SHOP DRAWING REVIEW

Job Title: Keith Corporation MOB for Cape Fear: Upfit

Shop Drawing Number: 28 31 11

Description of Items Received: Fire Alarm SD

SHEET:
FA-1
SHEET 2 OF 4

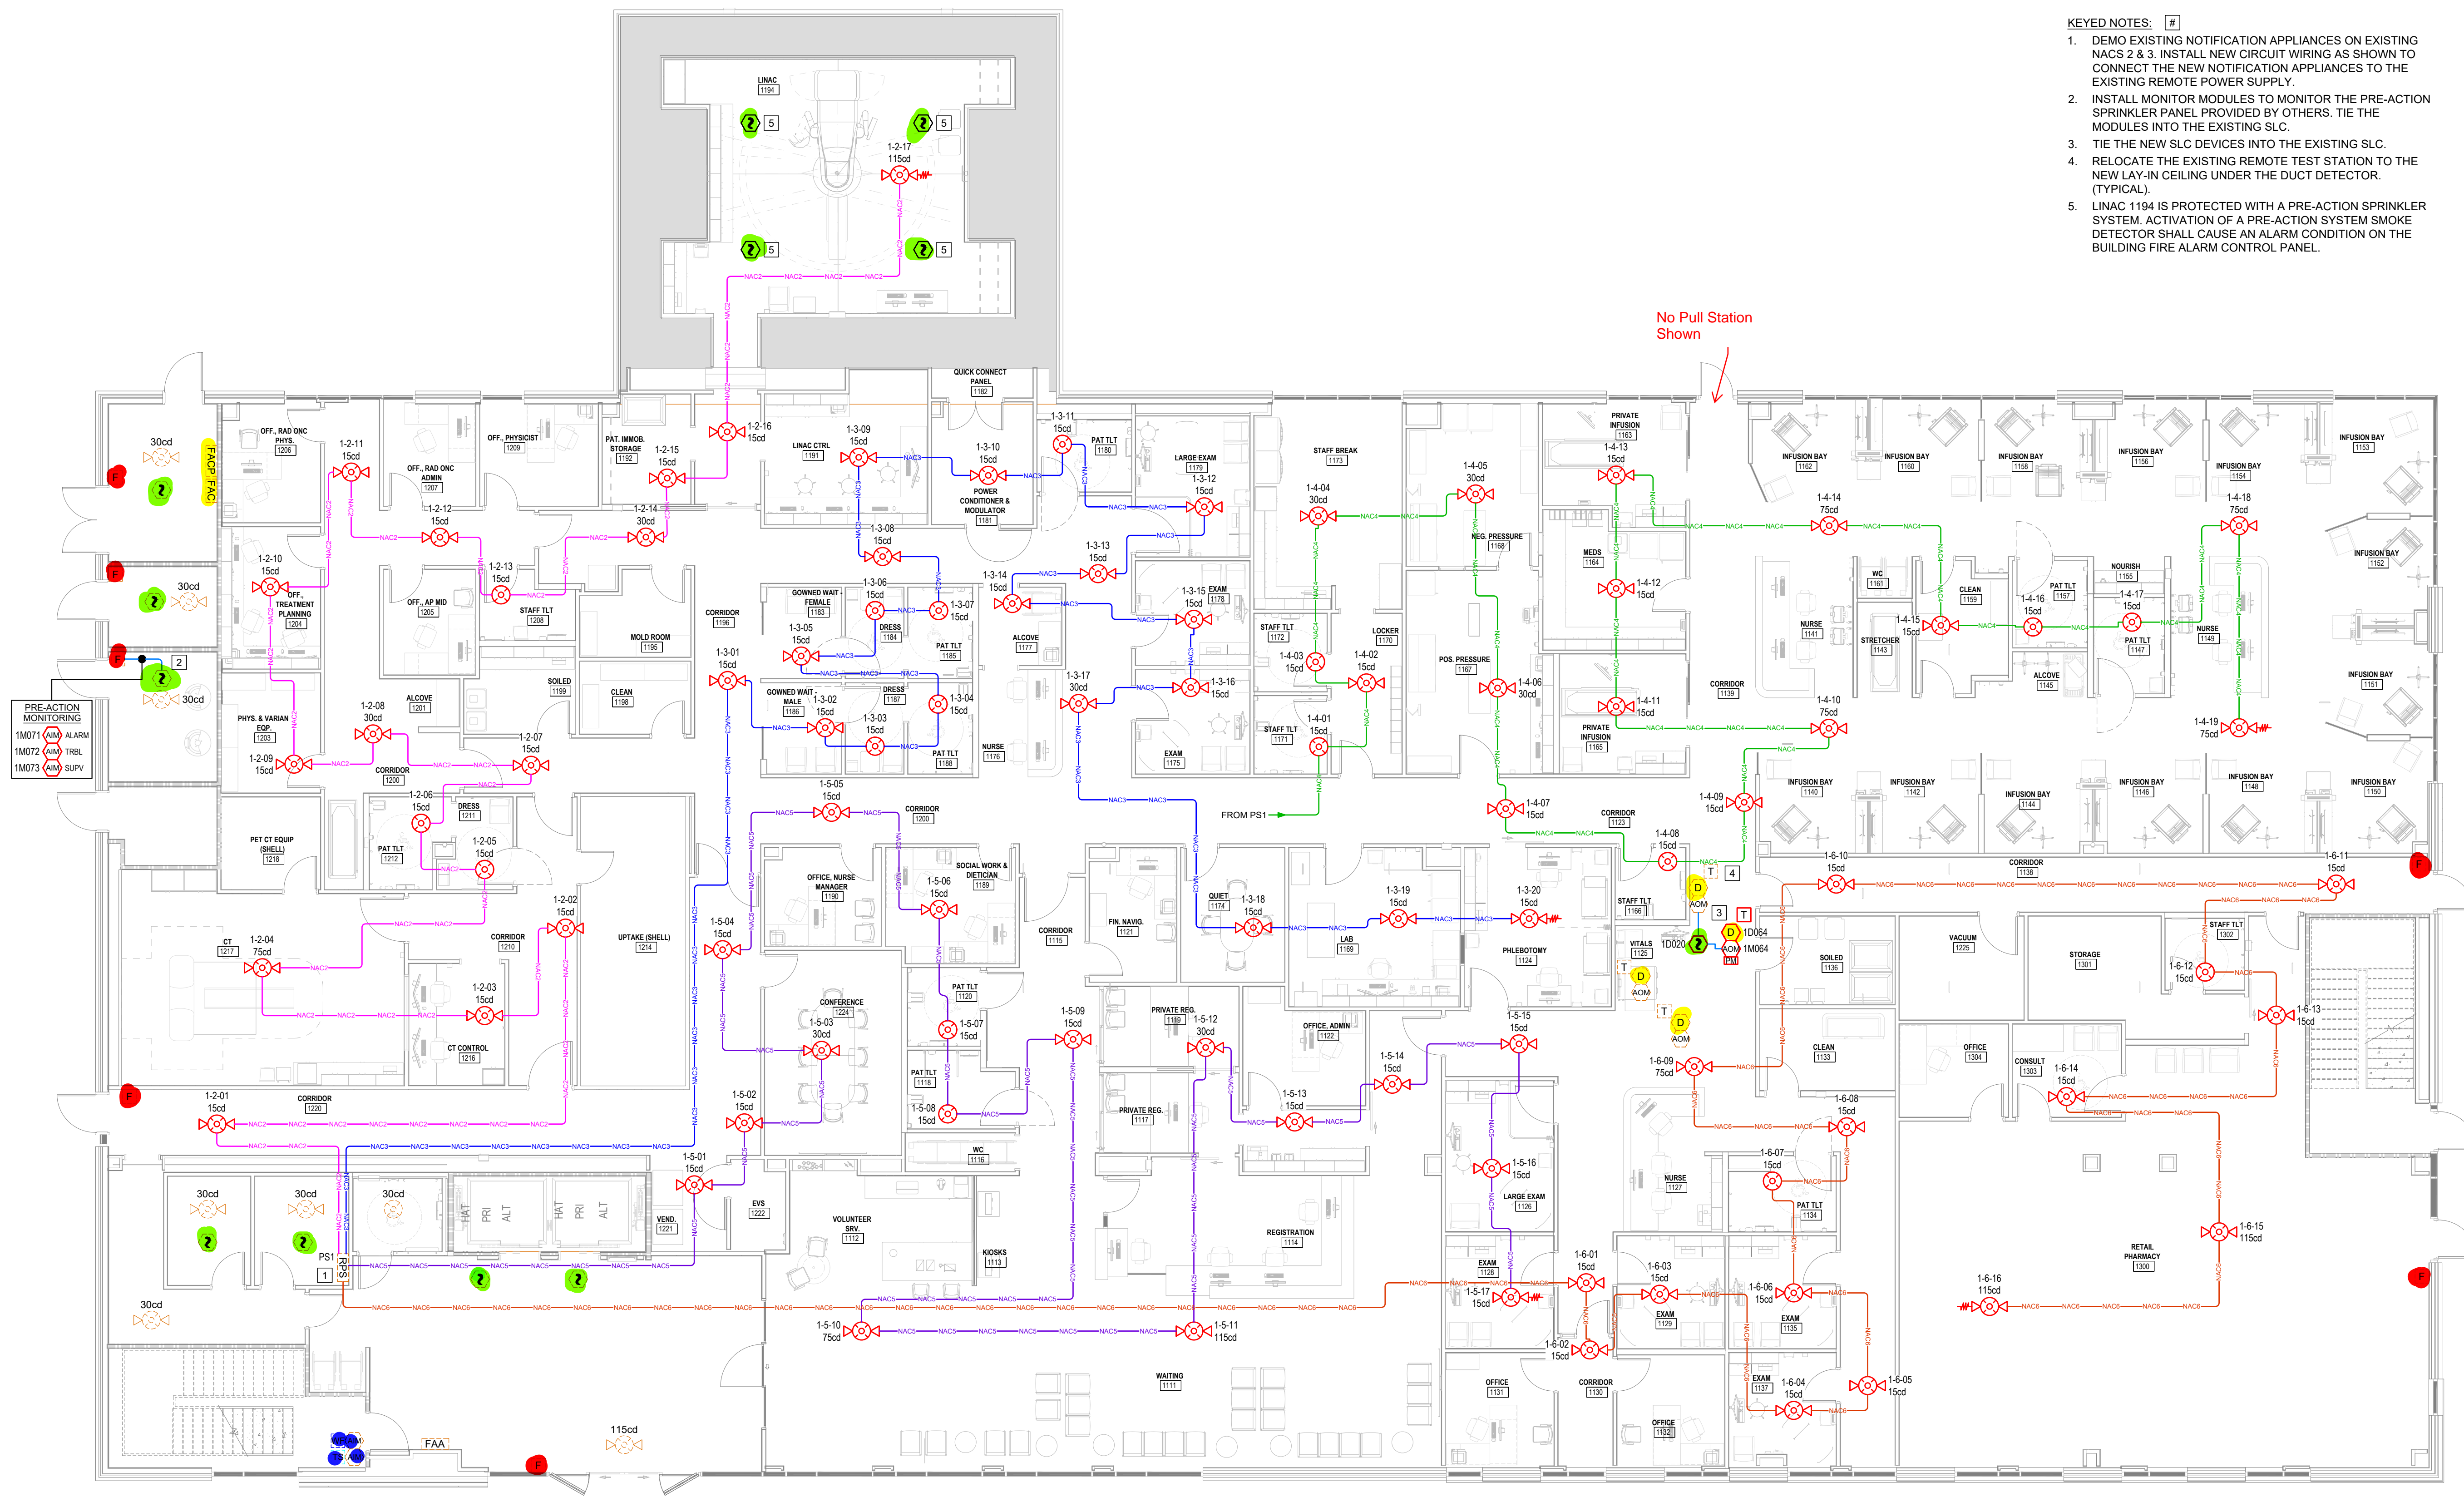
1. Coordinate entry of conduit for LINAC room 1194 with pre-determined location during design to adhere to shielding requirements.
2. Provide shut down relay for roof top unit RTU-4 and EF-4.
3. Provide additional pull station on North end of corridor 1139
4. Show connections for BDA system.
